## CITY OF PORTLAND

October 5, 2004

RE: 430 Riverside Street – 320-A-003 – I-M Zone

PROPOSED S

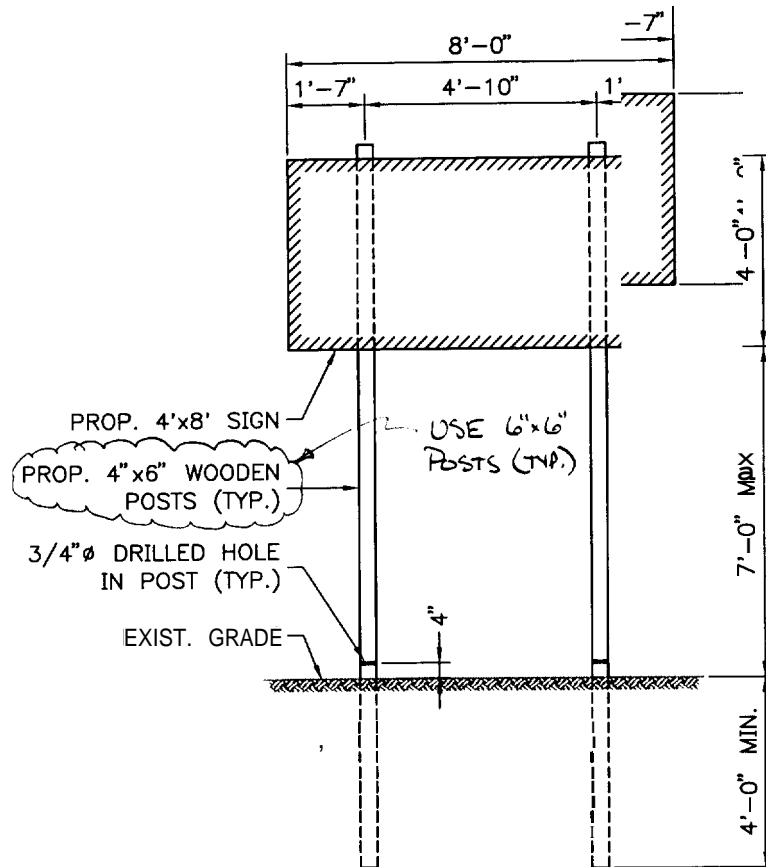
This property is located in an I-M Industrial Zone. Section 14-369.5(b) –Table 2.12 which only permits one single freestanding sign per lot. Currently there is a freestanding sign on this property. This proposal would make this a second sign on this lot.

It is also understood that this proposed sign is actually for a building on a different lot from which it will be placed. Off premise signs are not permitted in the City of Portland. Signage is considered to be accessory to principal uses (14-404). Signage is only permitted on the lot for which the principal use is located, not on off premise locations.
